# WATERLOO METRO QUARTER BUILDING 3&4

SSD-10437 - RESPONSES TO DPIE

PREPARED FOR WATERLOO DEVELOPER PTY LTD  
DOCUMENT NO. WMQ-BLD34-BSA-AR-RPT-DA211

Date of Issue 04.06.2021

Elevation - East

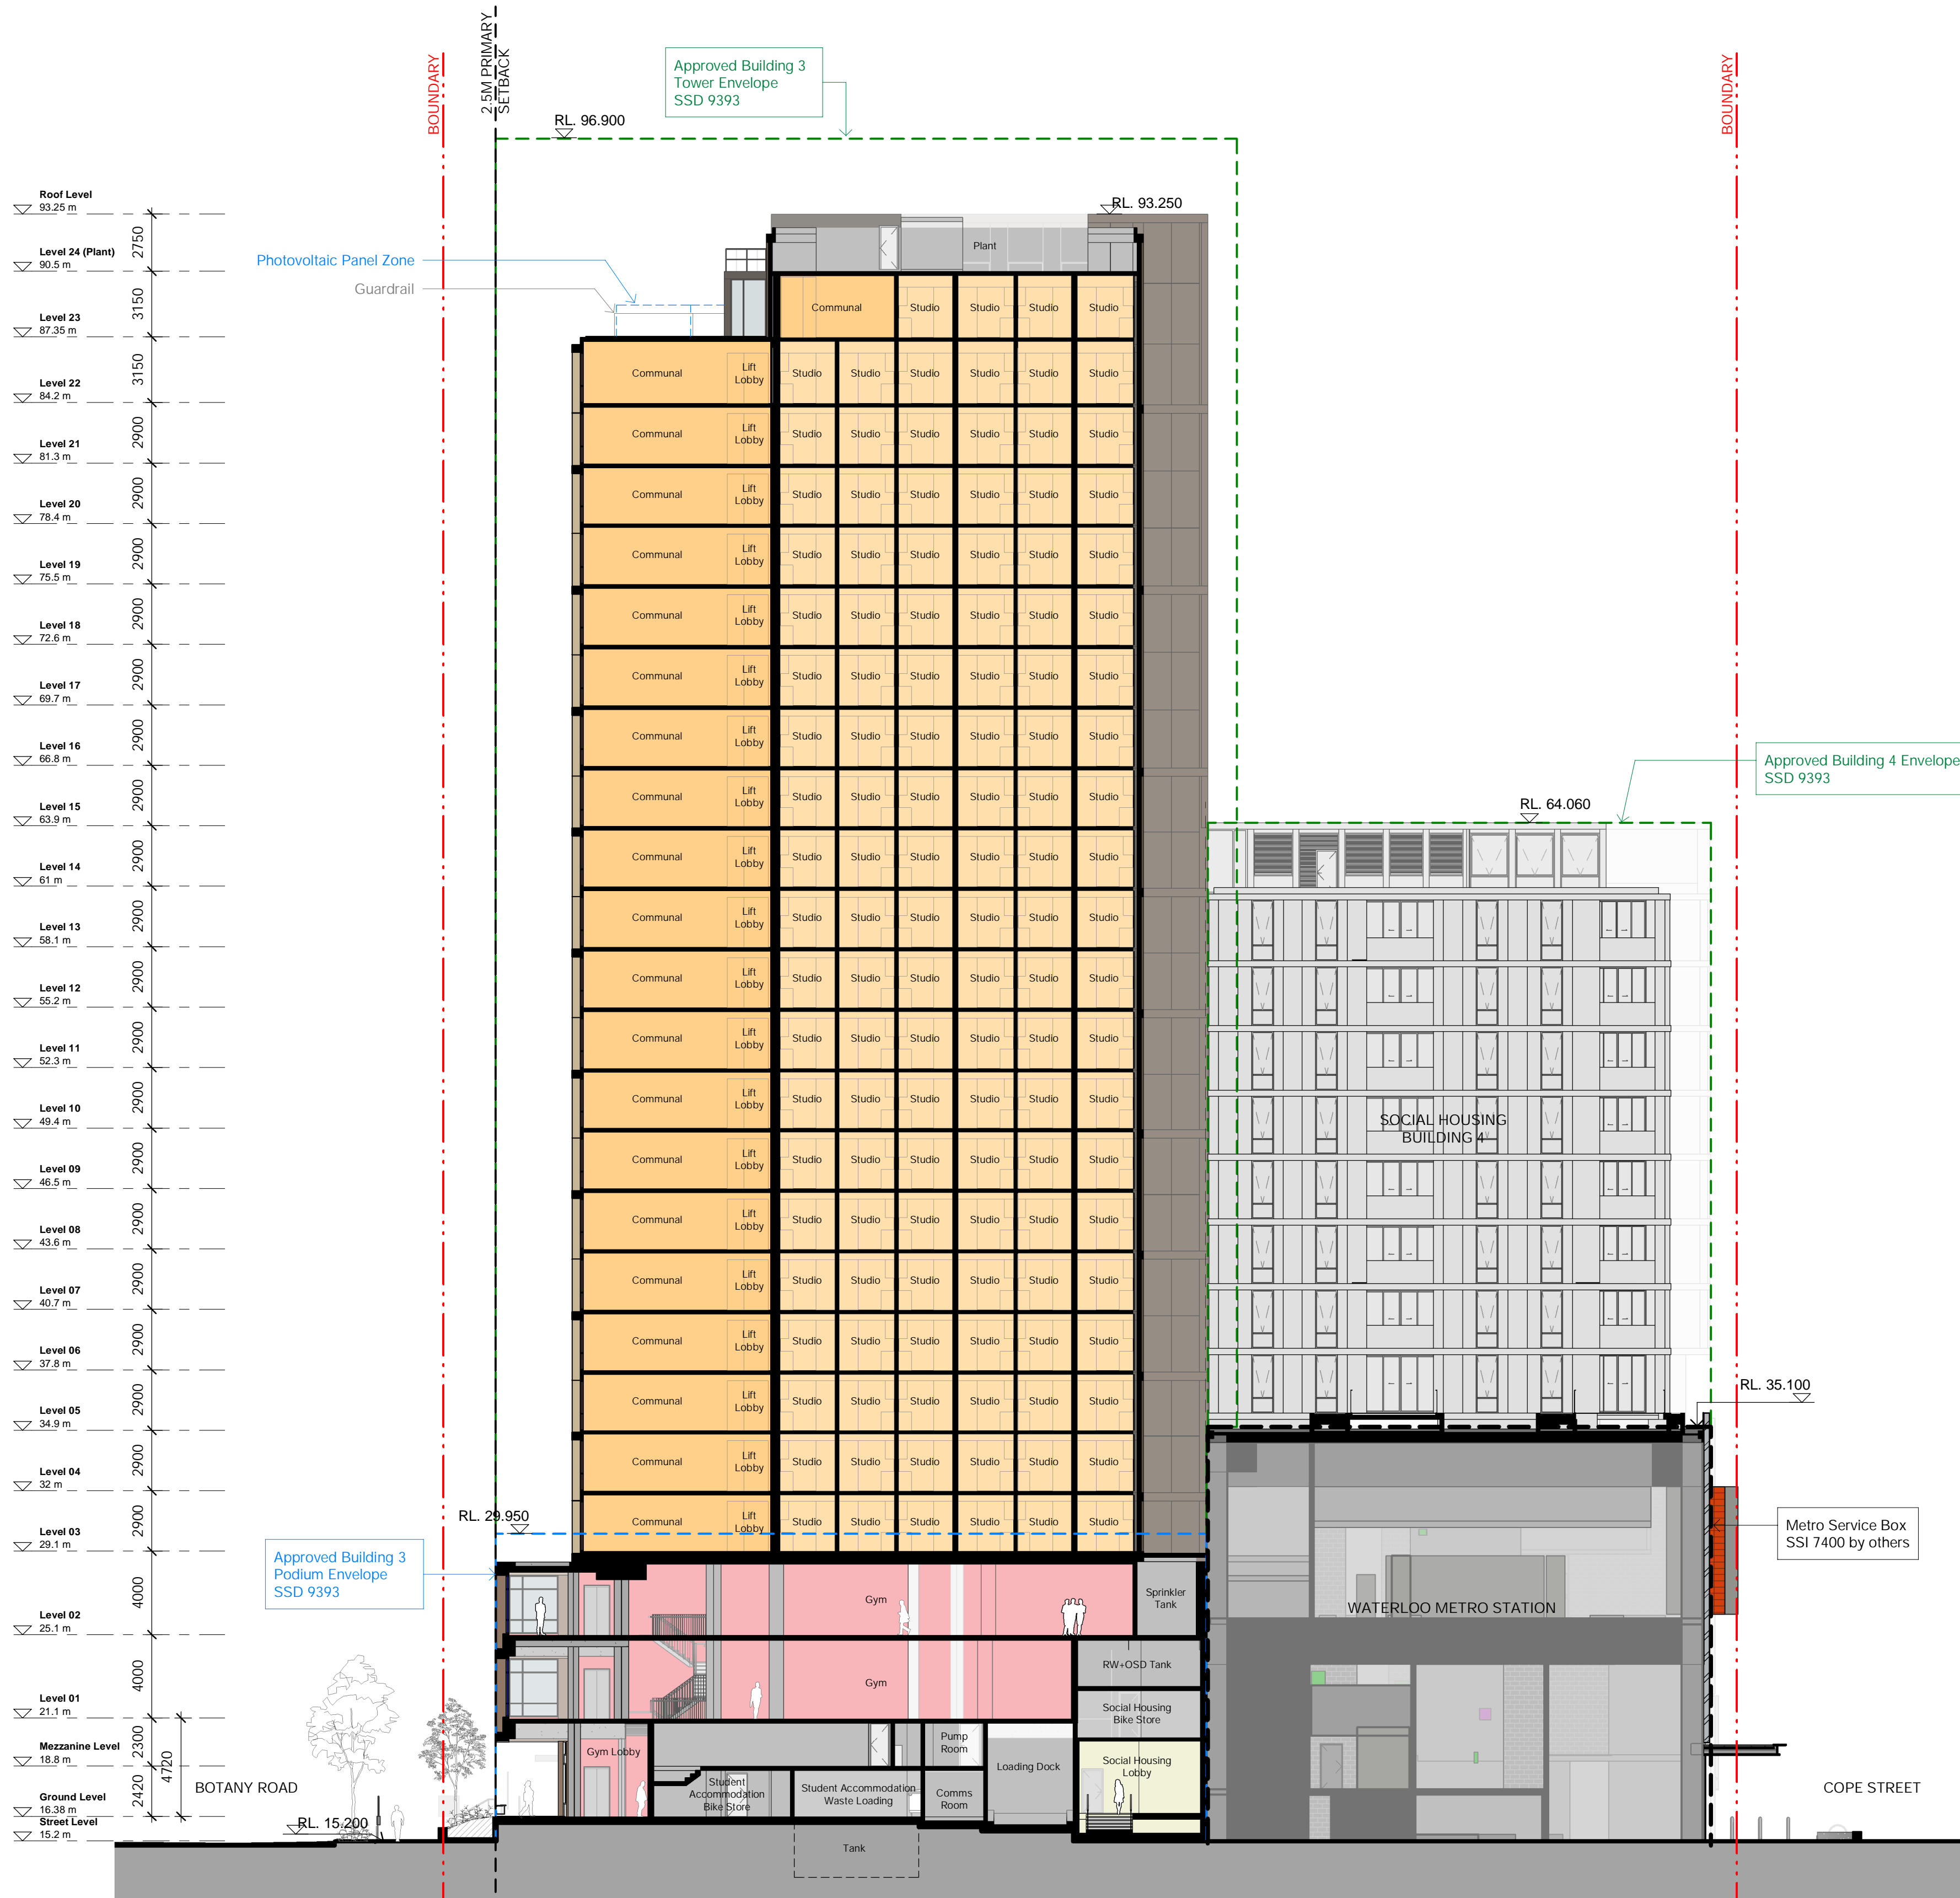
The additional glazing is acceptable, however, there is no variation in the colour of the grid and infill panels of the north or east walls. This monotony could be better treated with some variety in colour. A condition to this effect is recommended.  
(City of Sydney)

The design of the building ends have been developed in response to feedback from the DRP to ensure the facade design to these elevations are highly considered.

We believe the proposed design has a considered balance between built form articulation, fenestration and architectural expression through the expressed grid frame.

We have avoided pattern making through a variety of panel colours, instead favouring a more simple, elegant approach in keeping with the overall building architecture.
